Project Name: The Forefront at Thompson's Point Level I Site Alteration  
Project ID: 2017-020  
Address: 1 Thompson's Point, Portland, Maine 04102  
CBL: 201 A 005001  
Applicant: Chris Thompson  
Planner: Christine Grimando

**TO:** Christine Grimando, Senior Planner  
**FROM:** Lauren Swett, P.E.  
**DATE:** March 7, 2017  
**RE:** Thompson's Point Level I Site Alteration

Woodard & Curran has reviewed the Level I Site Alteration application for grading activities proposed at Thompson's Point. The site has previously been approved for a Master Development Plan, and the Level I Site Alteration has been reviewed with consideration to the previously approved plans.

SHEET TITLE
GRADING, EROSION AND SEDIMENT CONTROL PLAN

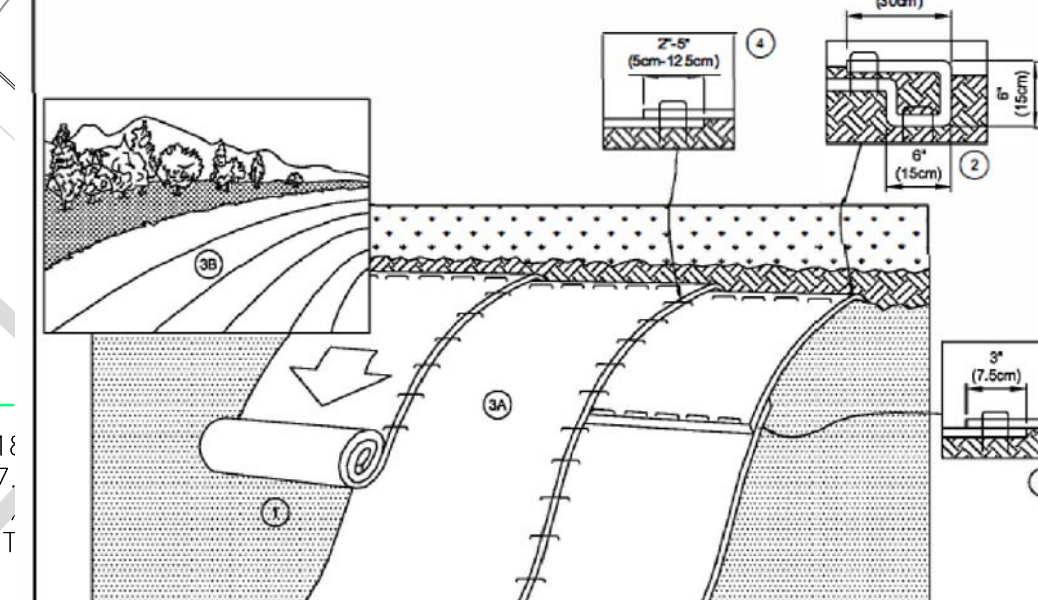
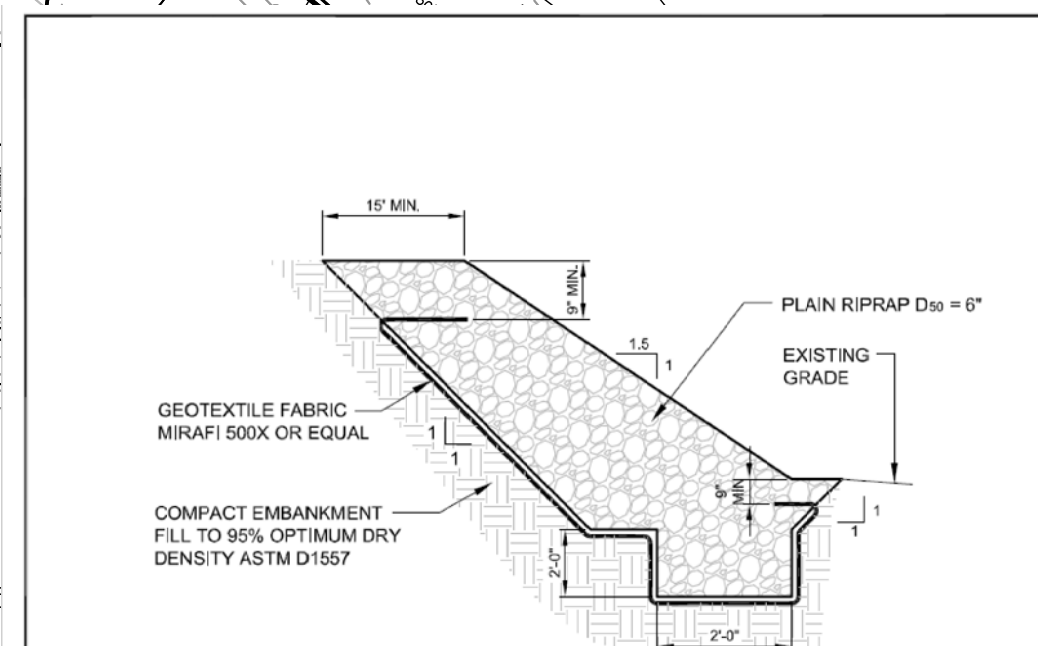
2. The plan identifies that the slopes will either be 1.5:1 slopes with rip rap or 2:1 slopes with erosion control mesh. It is assumed that this area will be loamed and seeded prior to installation of any erosion control fabric, but the Applicant should clarify.

3. The Applicant notes that they are working with CMP to coordinate the impacts around the utility poles and overhead lines that cross the northern corner of the site. The Applicant should confirm that any increases in grade under the overhead utility lines are acceptable for the height of those lines.

4. The Applicant is proposing to fill within a Portland Water District easement in the vicinity of a 30" forcemain. The Applicant should confirm that this filling will be acceptable to the Portland Water District.

1. Future site plan applications towards fulfillment of the approved Master Development Plan shall adjust stormwater management systems and site features for Zone H to be compatible with the proposed grade changes; and
2. Prior to conducting site work within the Central Maine Power easement, the applicant shall provide proof of coordination with CMP; and

3. Prior to conducting site work within the Portland Water District easement, the applicant shall provide proof of coordination with Portland Water District; and
4. The 25 foot Shoreland Zoning line shall be posted in the field in areas where the site work approaches this boundary, prior to the pre-construction meeting.
